Planning Application Ref: **AW/277/20/T**

Location: **52 Aldwick Avenue, Aldwick, PO21 3AQ**

Description of works: **Reduce crown of 1no. tulip tree height 9.5m and spread 7m. Reduce crown of 1no. bay tree to height 7.5m and spread 4.5m. Reduce crown of 1no. silver birch tree to height 5.5m and spread 3.5m**

- 1) Tulip tree
- 2) Bay tree
- 3) Silver Birch

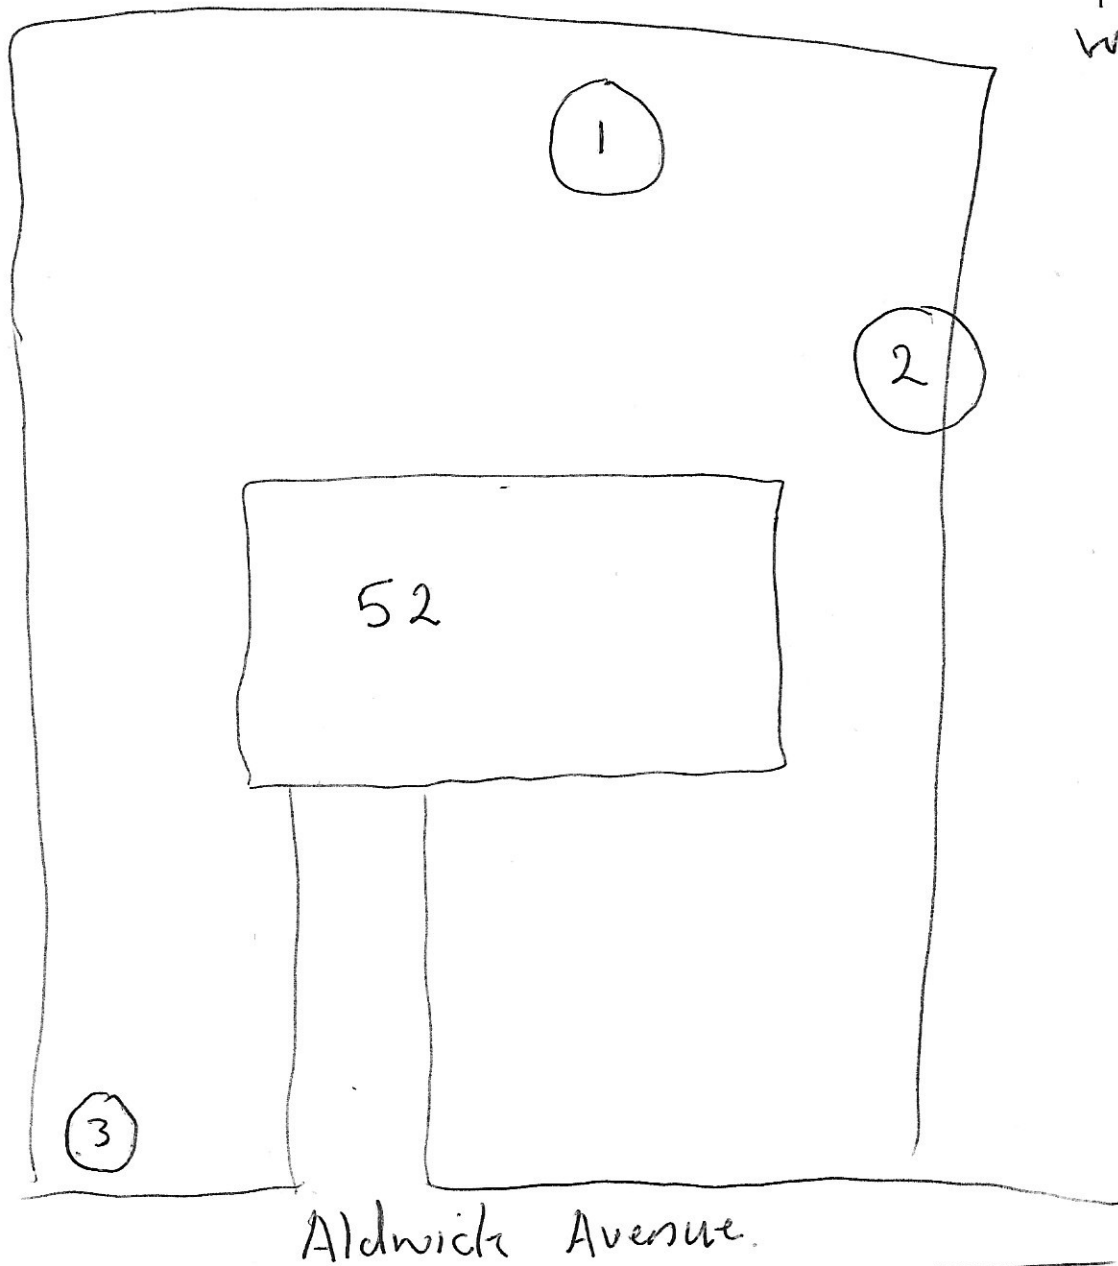
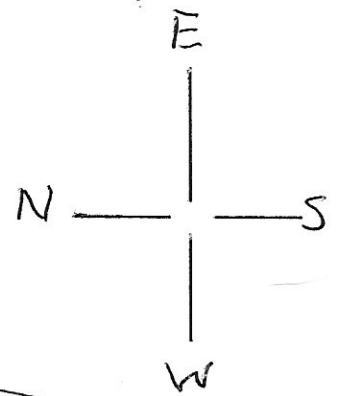
- There is no silver birch tree growing at the location shown, nor anywhere in the front garden of this plot and which is the subject of a Tree Preservation Order. As such, work proposed to item T3 (assumed to be the birch 2.5m due south of the applicant's driveway and not that which overhangs from neighbouring 56 Aldwick Avenue) does not require consent from the local planning authority.
